These comments and attached note have been prepared on behalf of Cheltenham Borough Council (CBC) Finance & Assets, who are the landowners of Barn Farm to the north west of M5 Junction 10.

The attenuation pond 1 proposed would make it difficult to provide a new junction at an appropriate standard to serve potential strategic and infrastructure development at the Barn Farm site in the future.

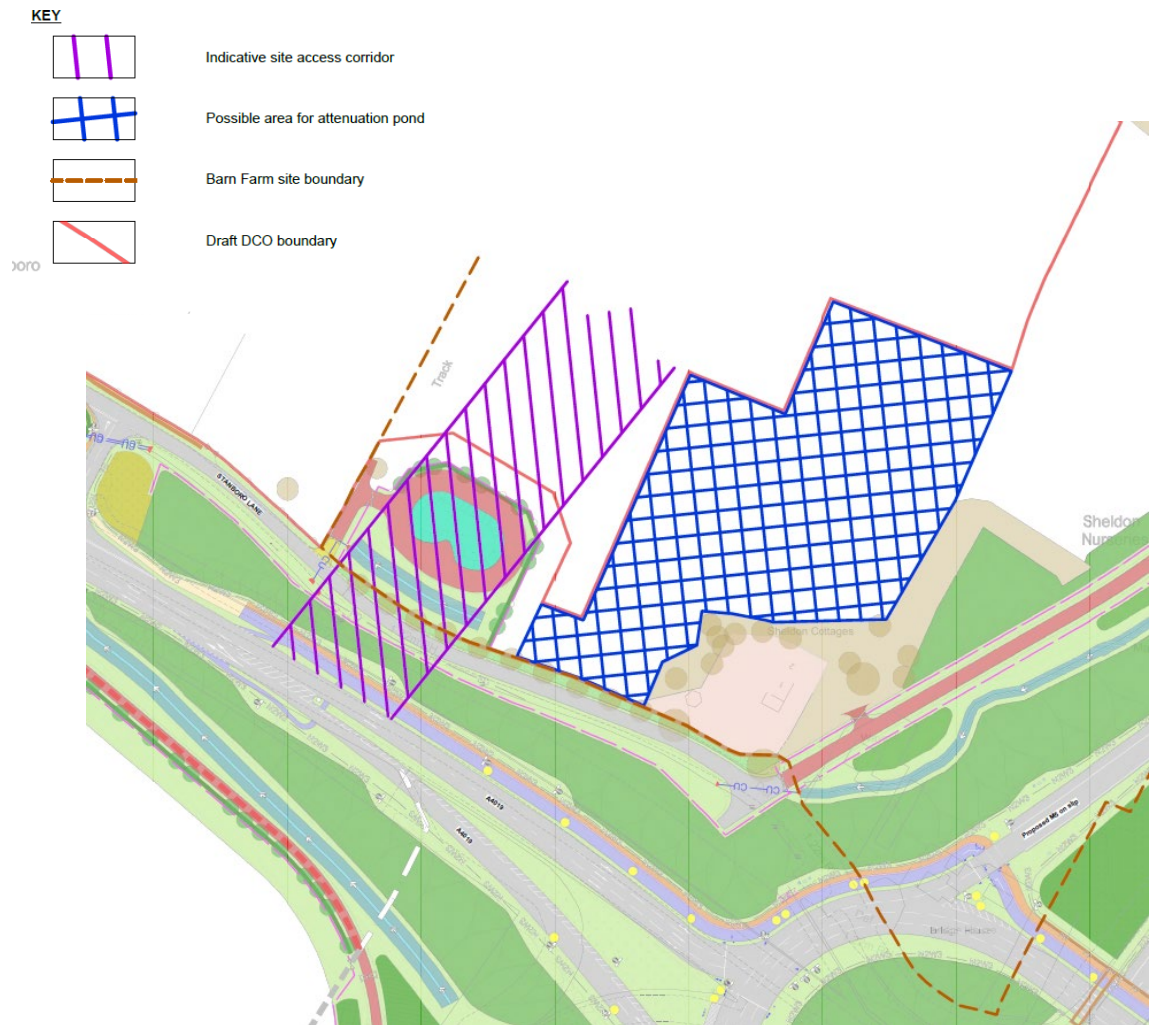
These comments and attached note have therefore been prepared to explore whether this attenuation pond can be moved or redesigned to enable a suitable junction to be provided to access the Barn Farm site.
